KITTITAS VALLEY FIRE & RESCUE

KVFR Prevention SEPA Comments

Project: Nunnally Project
Permit#: SE-21-00006
Date: 06/06/2022

1 PROPOSED GRAVEL RD PLAN VIEW
 1"=50'

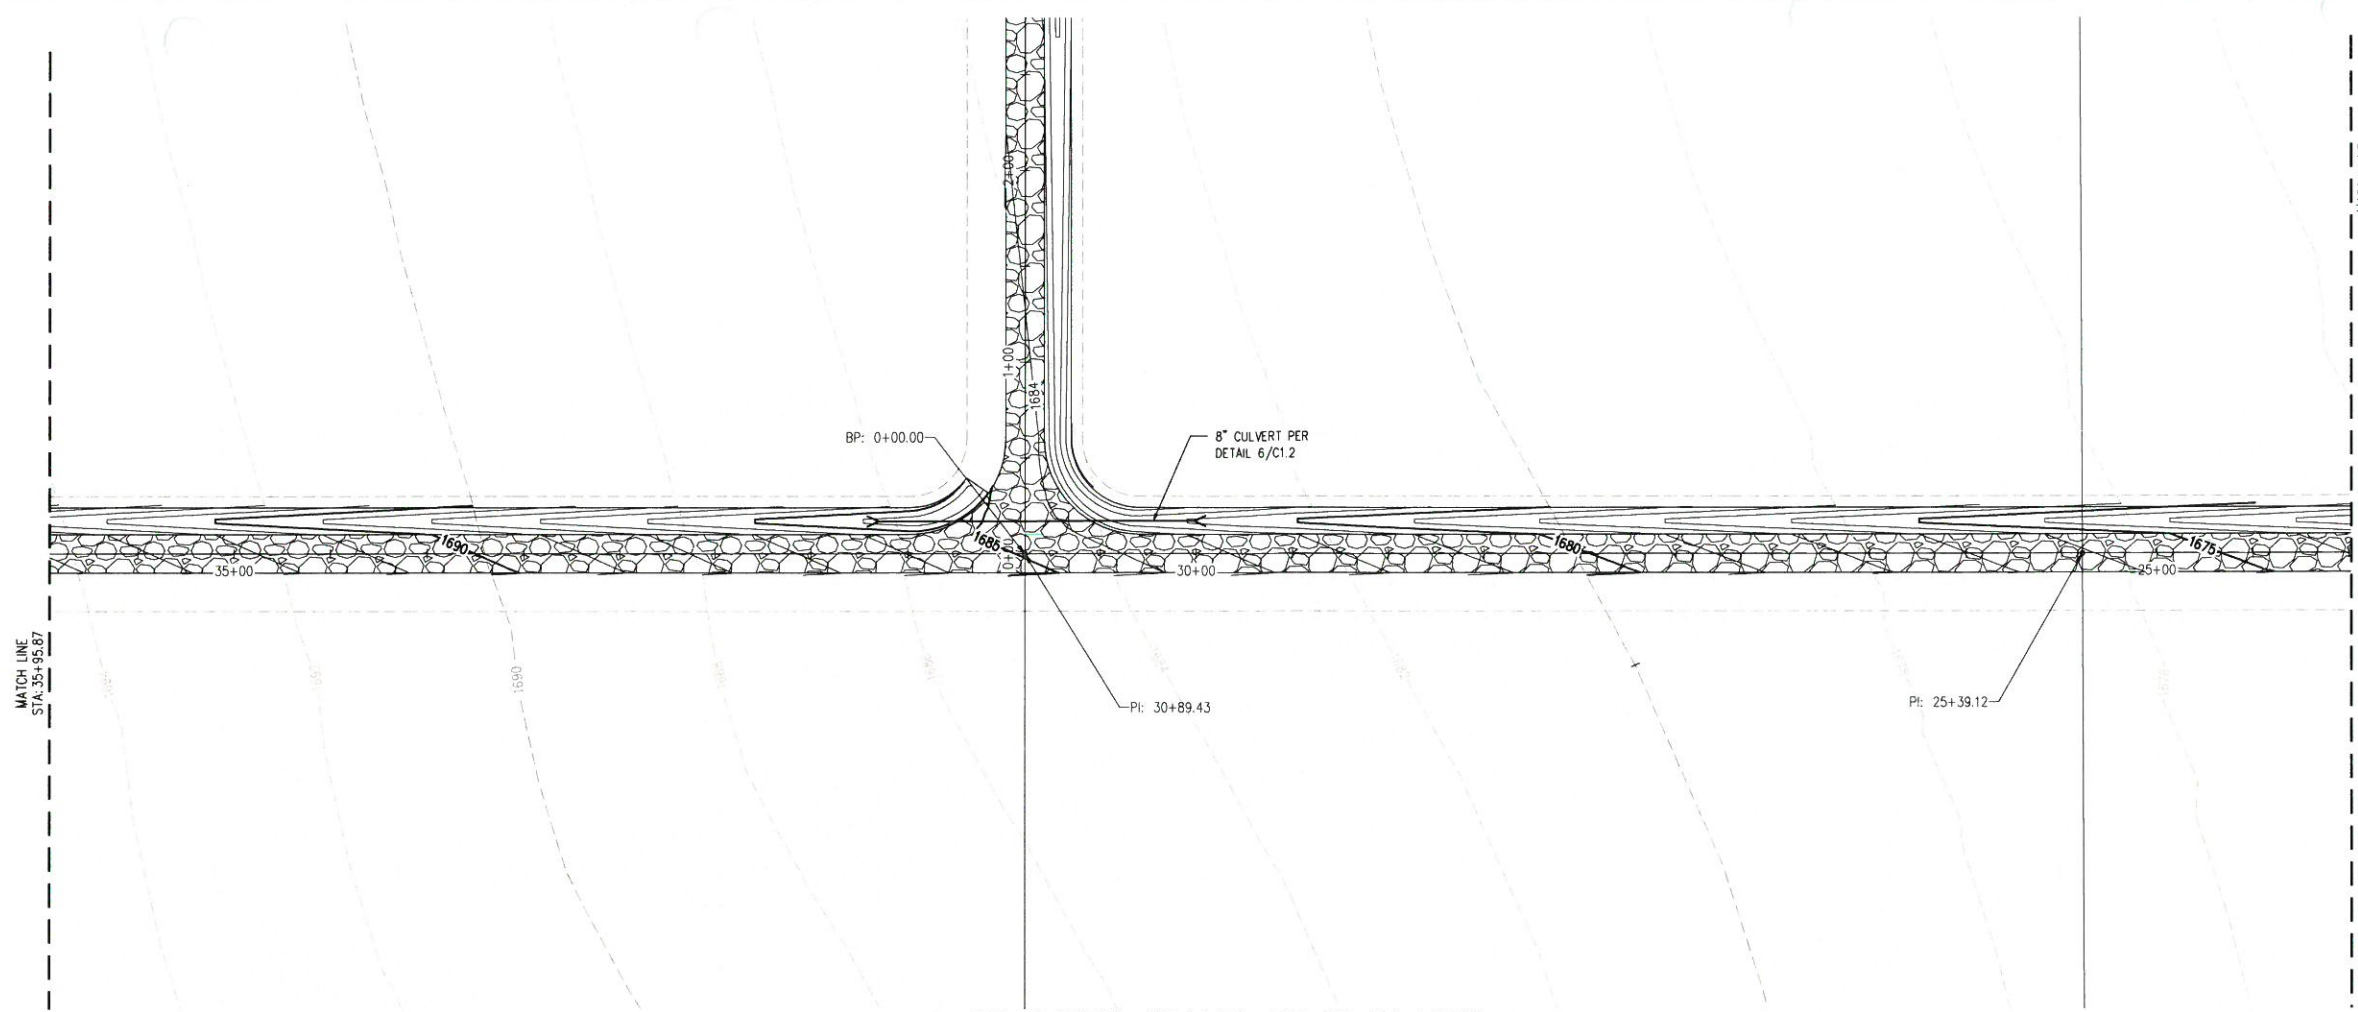
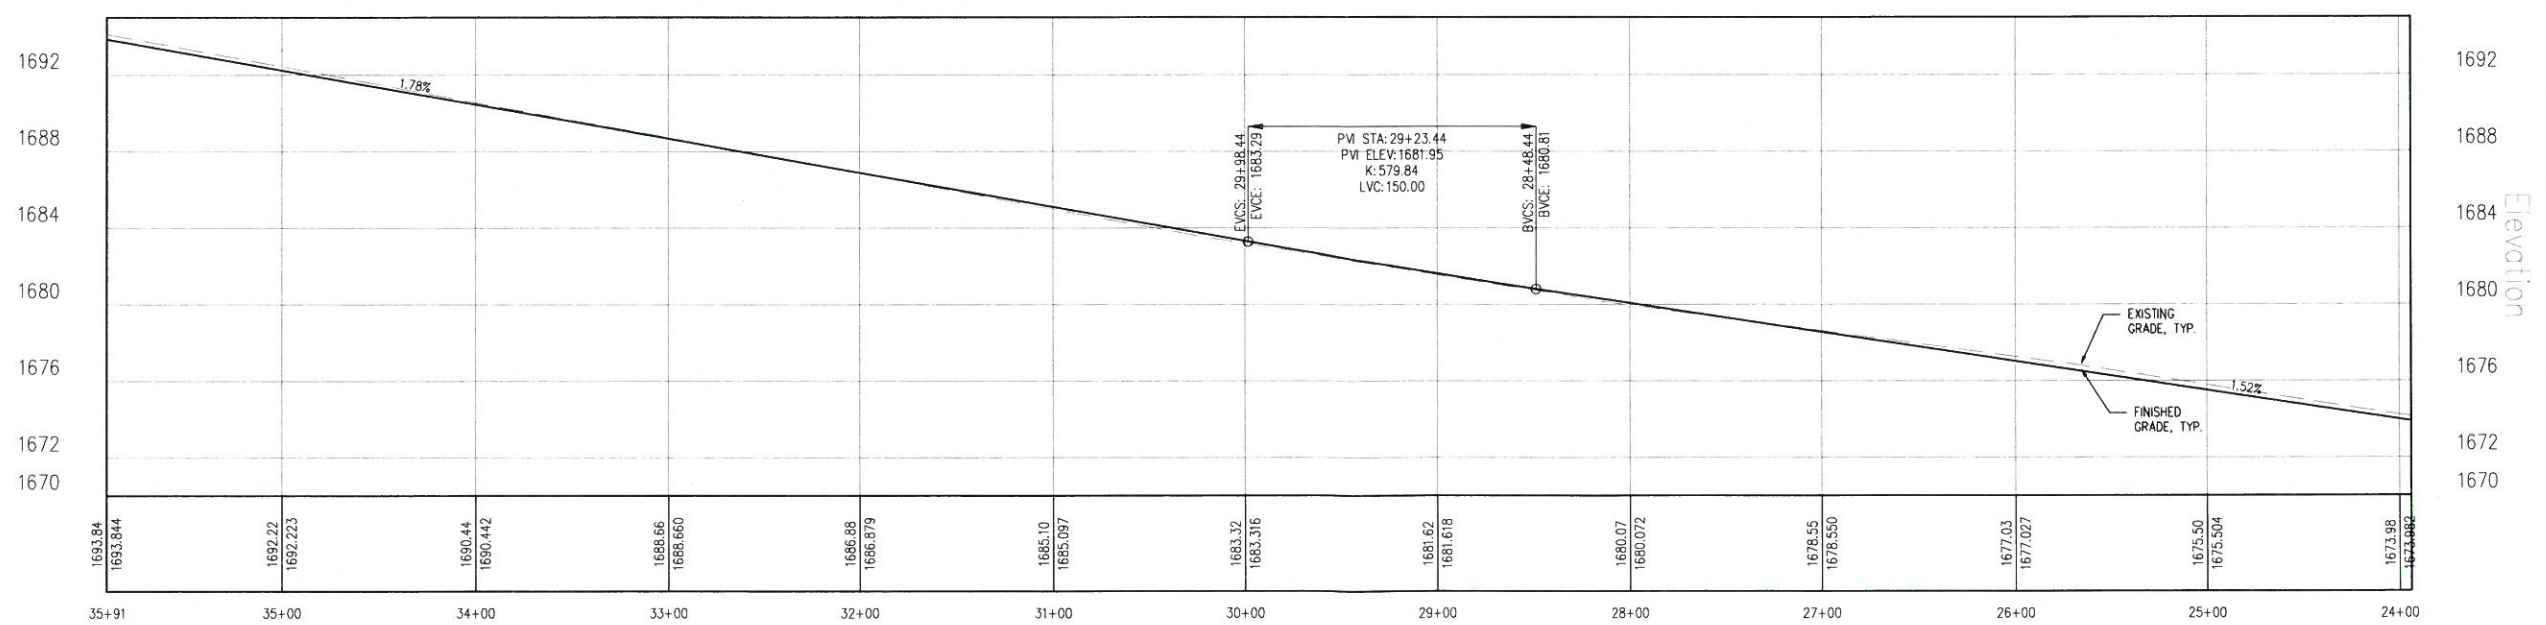
- Fire apparatus access roads exceeding 150' shall be provided with a temporary or permanent turnaround meeting the requirement 2018 IFC Appendix D.
- Fire apparatus access roads shall not exceed 10% in grade. This is especially critical in our valley's climate.
- The IFC Appendix D requires the road be a minimum of 20' wide and capable of supporting an imposed load of at least 75,000 lbs.
- Our standard turning radius is a minimum of 23' inside and 45' outside.
- Water supply meeting Kittitas County requirements.
